Charlotte Department of Transportation

Memorandum

Subject: Rezoning Petition 08-083: Located on the northeast corner of the Plaza and Barrington Drive.

EXISTING SITE PLAN

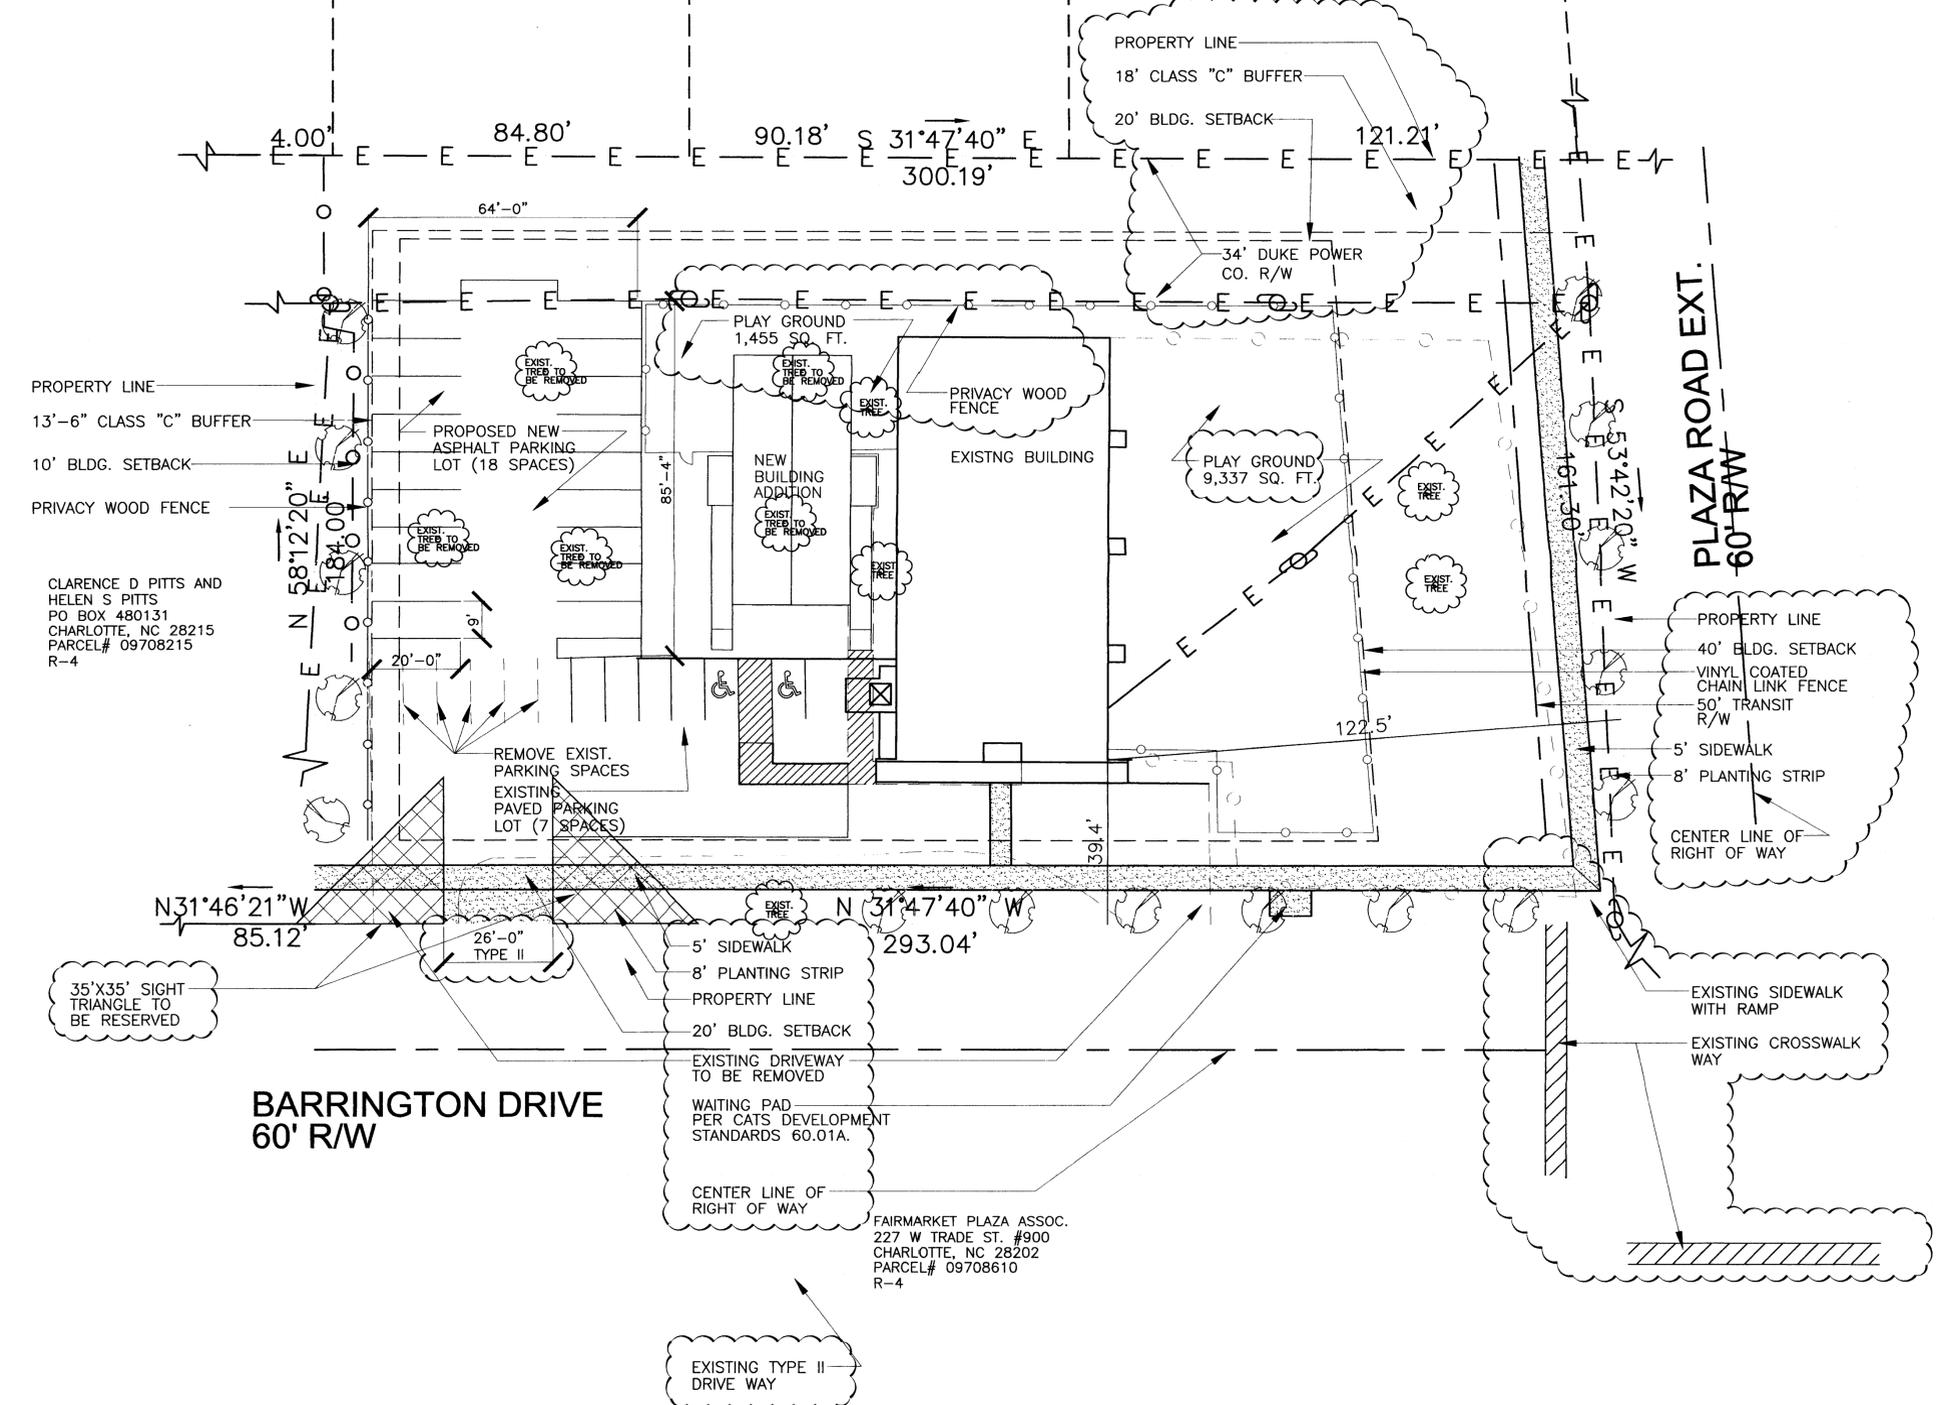
1. The developer must provide 8-foot planting strips and 6-foot sidewalks along both The Plaza and Barrington Drive. The note concerning variable planting strip width to protect existing trees needs to be deleted.
2. No maneuvering is allowed in the setback. Any existing asphalt within the setback needs to be removed.
3. The existing driveways are in disrepair and need to be replaced during construction. As part of this work the driveway closest to the northern property line needs to be moved to a

location in alignment with the new parking lot aisle. The driveway needs to be Type II Modified and 26 feet in width.

4. The revised site plan needs to more clearly indicate existing sidewalks, accessible ramps, road right-of-way widths (both sides), and roadway centerline.

1. The developer needs to provide 5-foot minimum internal sidewalks connecting the primary building entrance with Barrington Drive.

The Plaza is a major thoroughfare requiring a minimum of 100 feet of right-of-way. The developer/petitioner should convey right-of-way in fee simple title to meet this requirement, measuring 50 feet from the centerline of the roadway.

Adequate sight triangles must be reserved at the existing/proposed street entrance(s). Two 35' x 35' sight triangles are required for the entrance(s) to meet requirements. All proposed trees, berms, walls, fences, and/or identification signs must not interfere with sight distance at the entrance(s). Such items should be identified on the site plan.
